Pear tree Hill Solar Farm

Environmental Statement Addendum

Revision 5

Application Document Ref: EN010157/APP/8.2

Figure 1.2: Land Areas and Cable Routes Plan with Field Numbering System

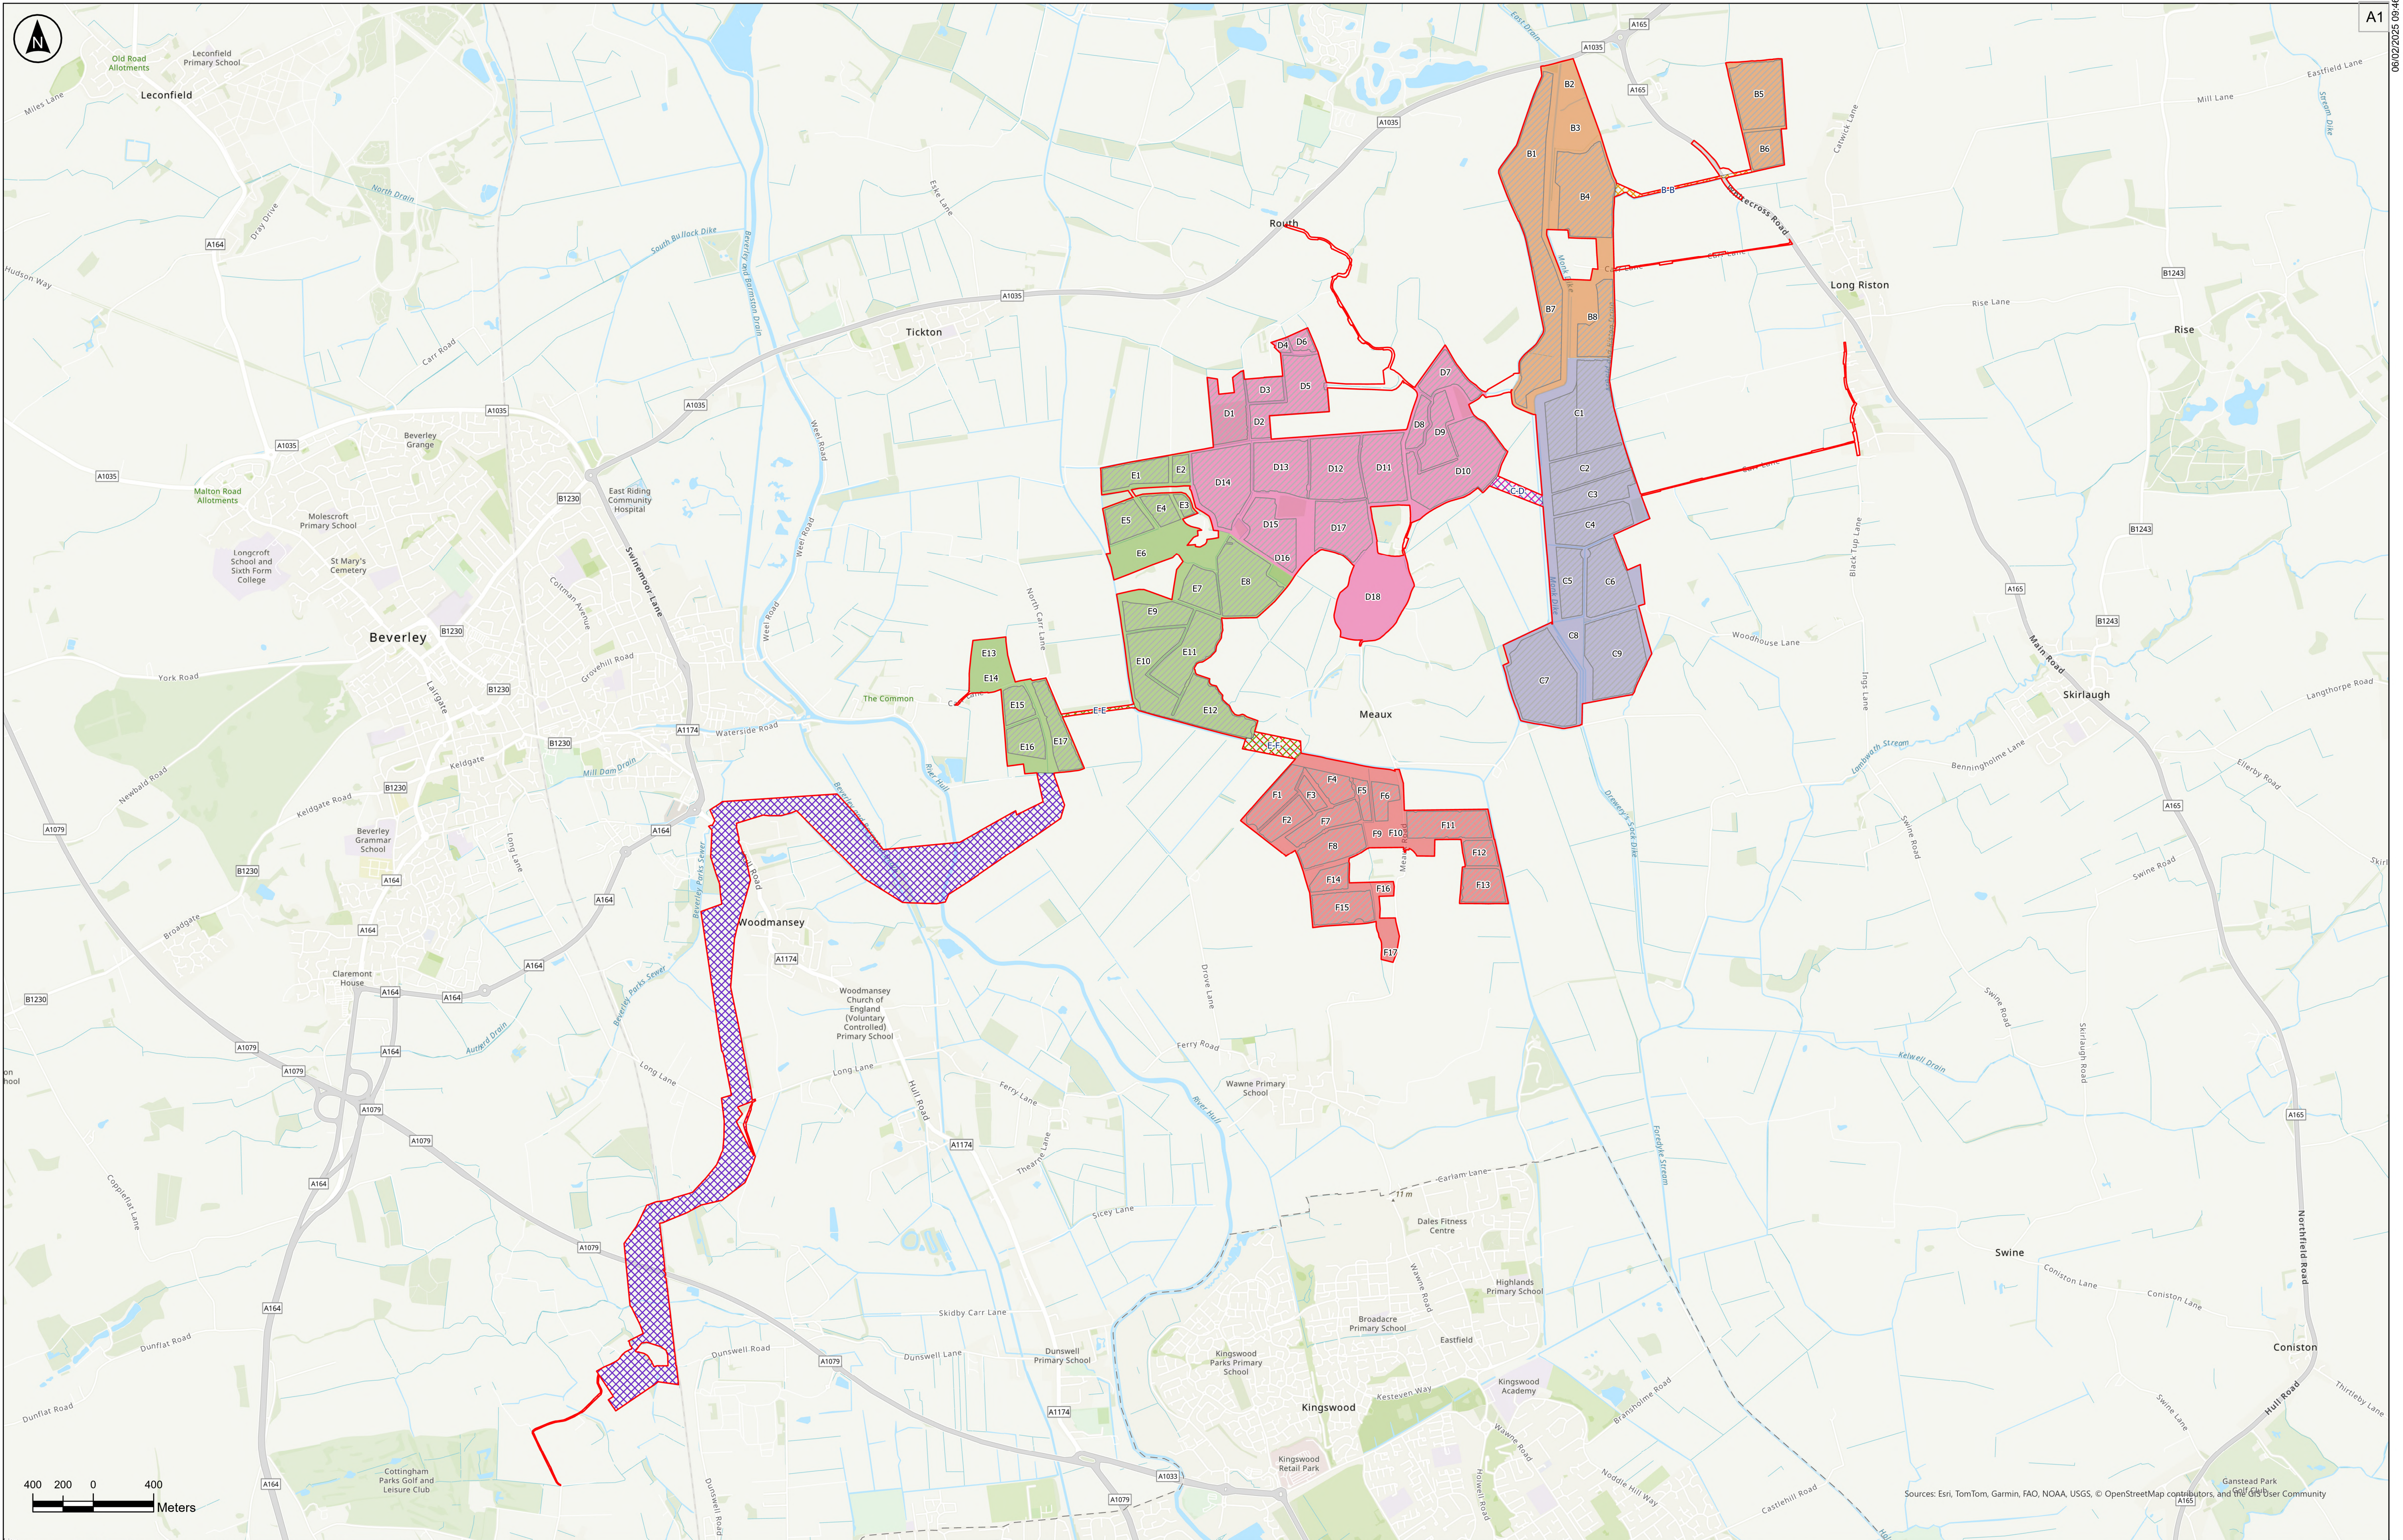
Document reference	Reason for amendment	ES Amendment July 2025
	Figure 1.2 also requires amendment to reflect the removal of plots 10-4, 10-5 and 10-6 as part of change/correction 2.	
ES Volume 3, Figure 2.1: Environmental Features Plan [APP-054]	Figure 2.1 requires amendment to reflect the removal of plots 10-4, 10-5 and 10-6 as part of change/correction 2.	
ES Volume 3, Figure 3.1: Indicative Operational Layout Plan [APP-055]	Figure 3.1 requires amendment to reflect the removal of a section of solar array from Land Area B as part of change/correction 1. Figure 3.1 also requires amendment to reflect the removal of plots 10-4, 10-5 and 10-6 as part of change/correction 2.	
ES Volume 3, Figure 3.2: Heights Parameters Zonal Plan [APP-056]	Figure 3.2 requires amendment to reflect the removal of a section of solar array from Land Area B as part of change/correction 1. Figure 3.2 also requires amendment to reflect the removal of plots 10-4, 10-5 and 10-6 as part of change/correction 2.

Figure 14.3: Public Rights of Way and Long Distance Paths Within and Adjacent to the Proposed Development

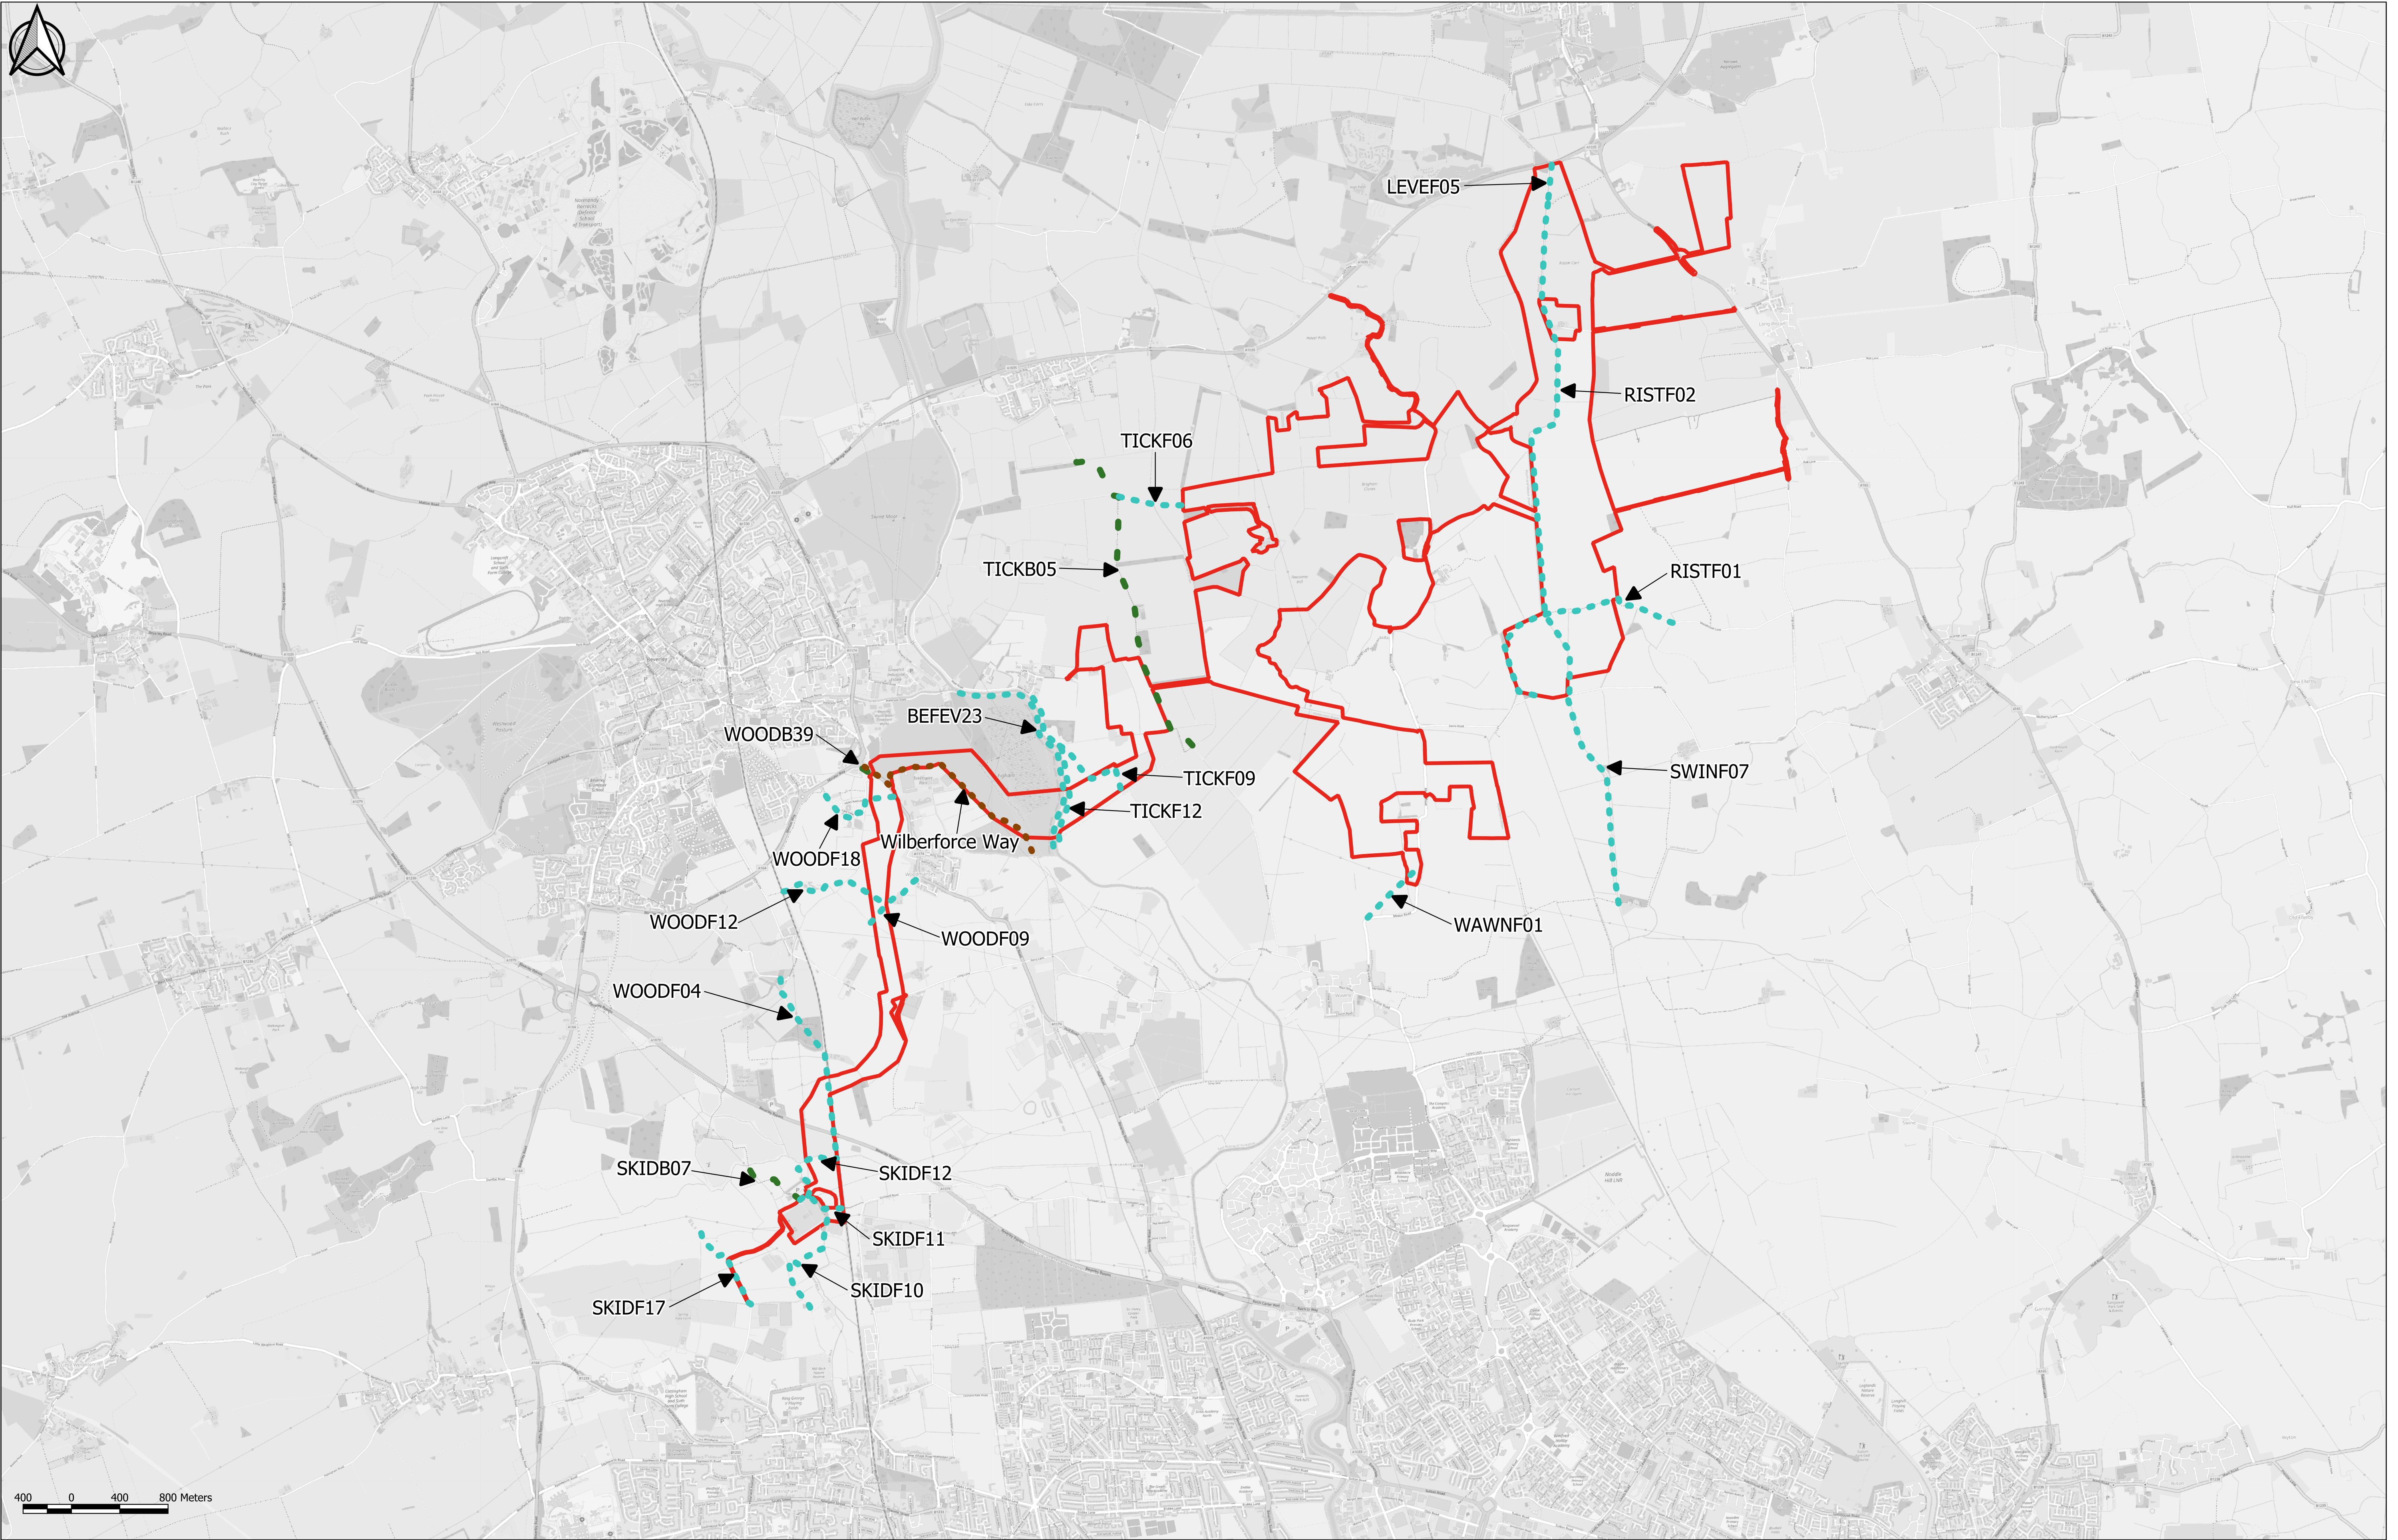
Document reference	Reason for amendment	ES Amendment July 2025
ES Volume 3, Figure 14.3: Public Rights of Way and Long Distance Paths Within and Adjacent to the Proposed Development [APP-091]	Figure 14.3 requires amendment to reflect the removal of plots 10-4, 10-5 and 10-6 as part of change/correction 2.	
ES Volume 3, Figure 14.4: Link Sensitivity [APP-092]	Figure 14.4 requires amendment to reflect the removal of plots 10-4, 10-5 and 10-6 as part of change/correction 2.	
ES Volume 3, Figure 15.1: Other Existing and/or Approved Development [APP-093]	Figure 15.1 requires amendment to reflect the removal of plots 10-4, 10-5 and 10-6 as part of change/correction 2.
